**Transport  
for NSW**

**Sydney International Convention Exhibition and Entertainment Precinct (SICEEP) –  
International Convention Centre (ICC) Hotel - SSD 6116**

Thank you for letter dated 27 March 2014 regarding the above. Please accept our letter as a joint Transport for NSW (TfNSW), Roads and Maritime Services (RMS) and RailCorp comments on the response to submissions for the above proposal.

The following comments are provided on the responses to submissions prepared by JBA Planning on behalf of Lend Lease (Haymarket) Pty Ltd.

**6.99m COASTER BUS
PORTE COCHERE DROP OFF**
1 : 250

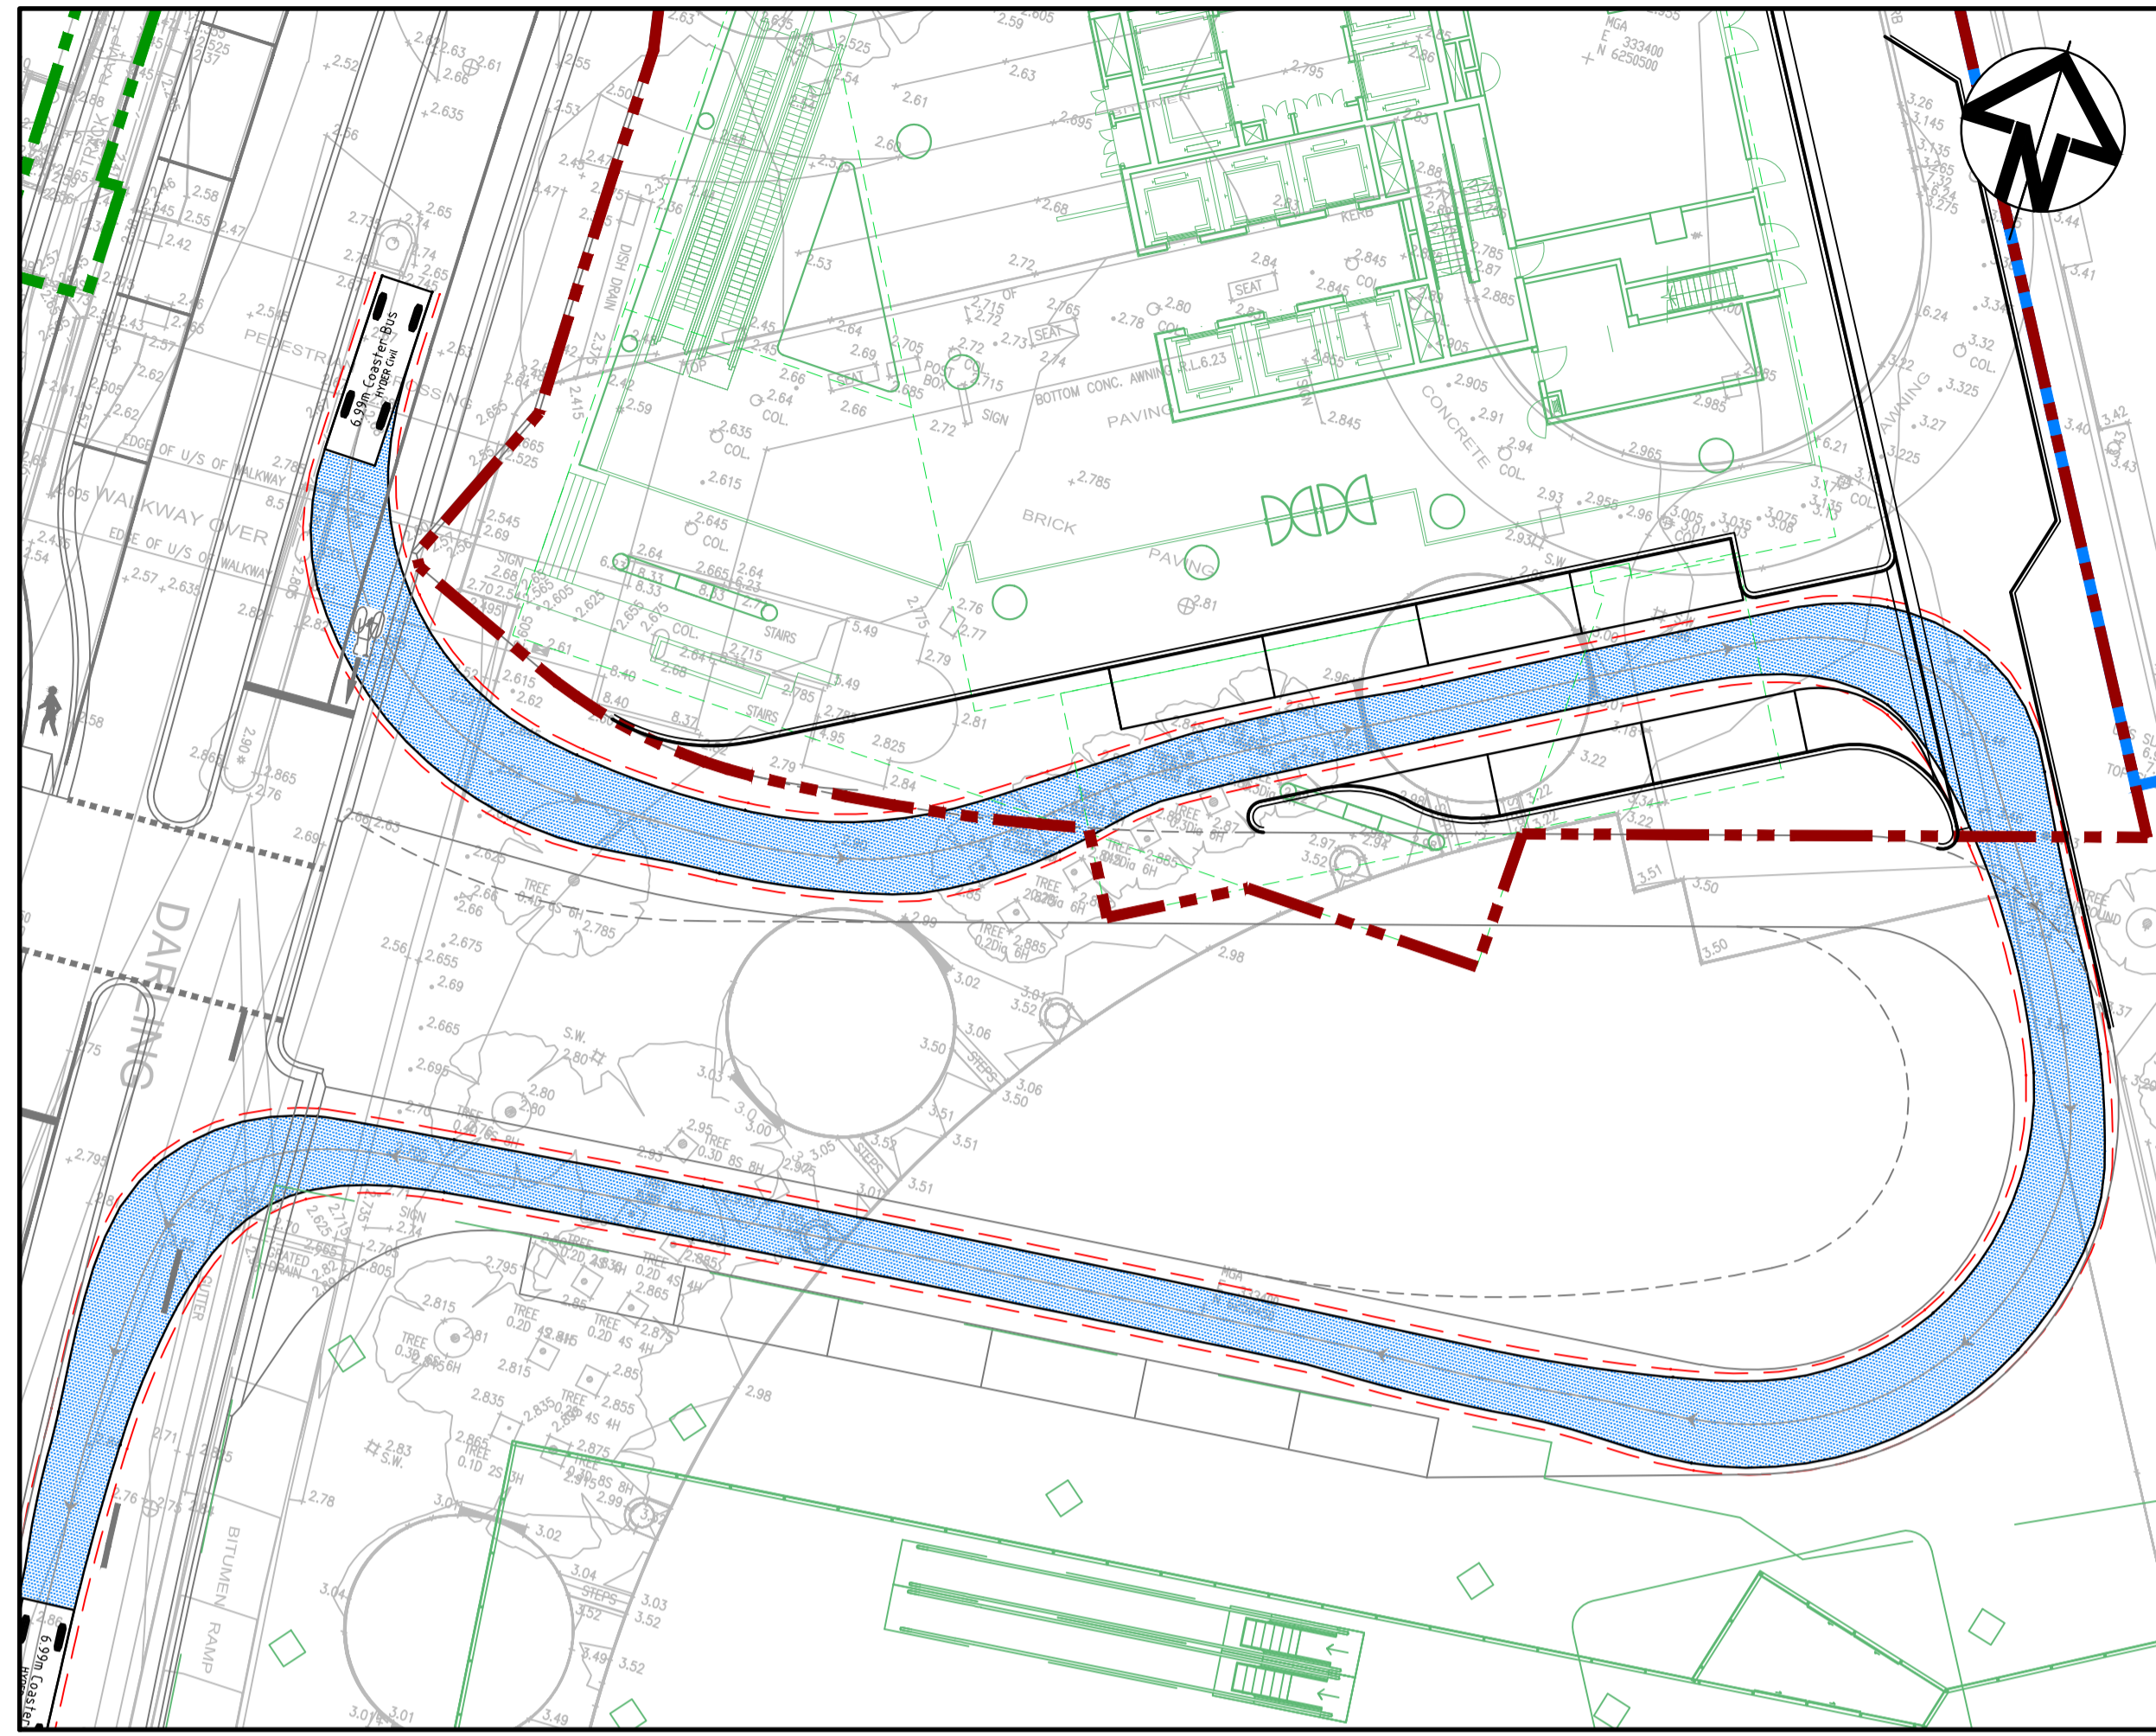
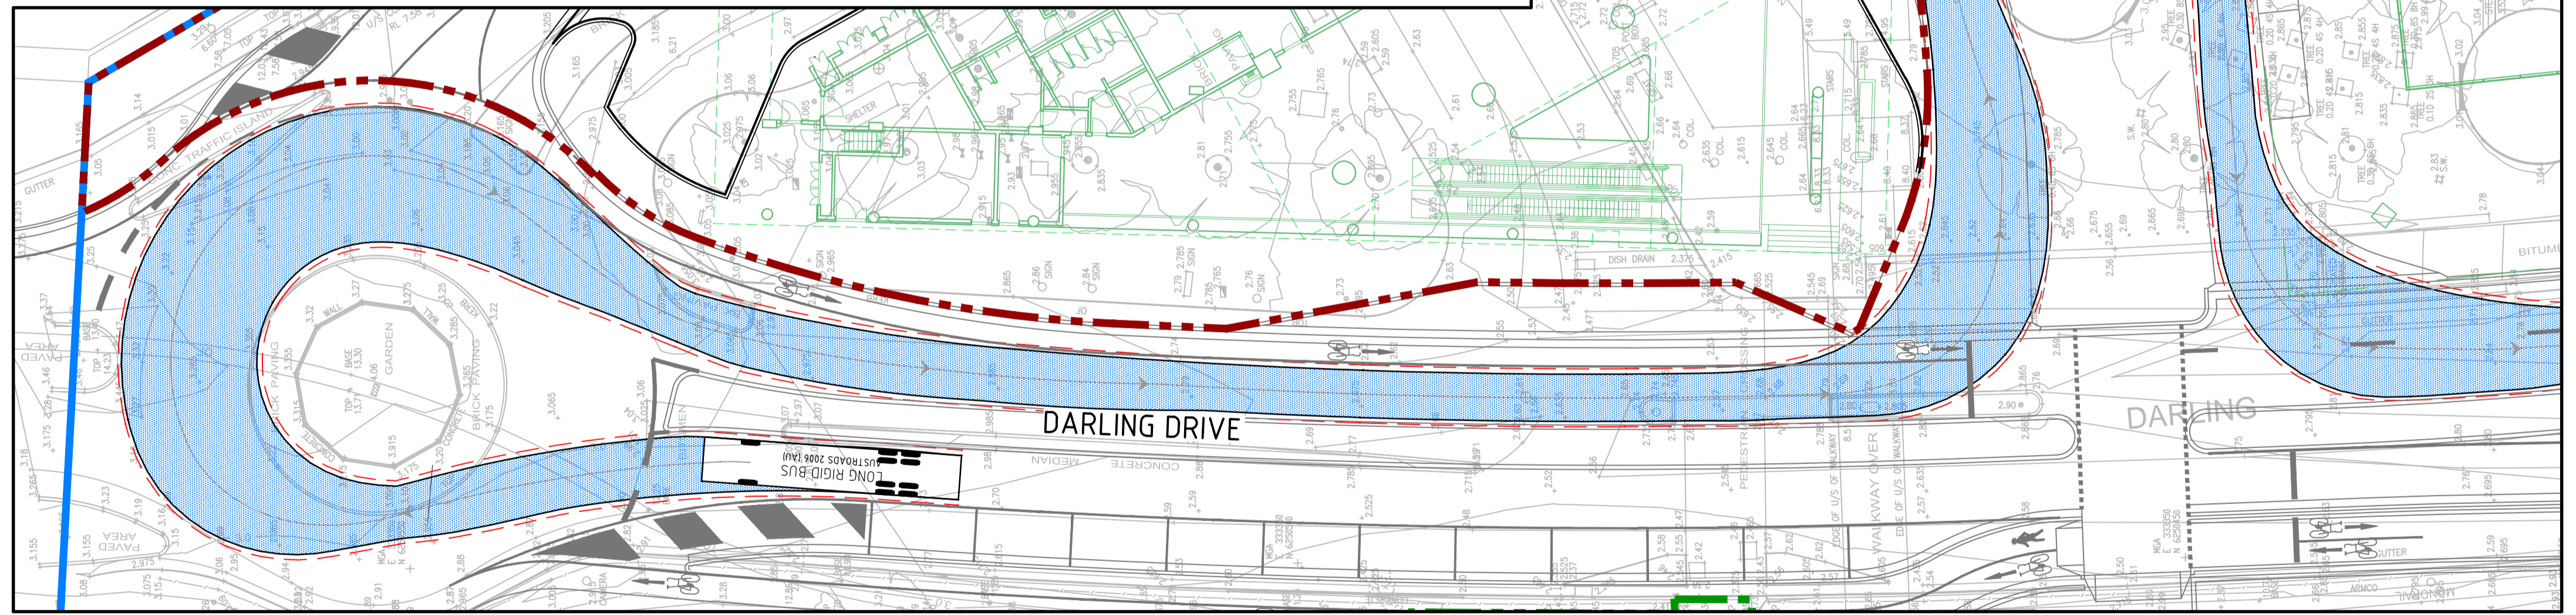
TfNSW requests that pedestrian/vehicle conflicts on the pedestrian link between the ICC hotel and the Convention Light Rail stop be assessed, due to the proposed location of the porte-cochere and associated vehicle movements in this area. The pedestrian connection along this link must be safe, efficient and clearly delineated.

Vehicles entering Porte Cochere shall be restricted up to 7 metres in length. For 14 metres buses and coaches the access route shall be via Darling Drive then the loop road through the adjacent Harbourside Place. This shall be enforced by internal signposting within the subject site.
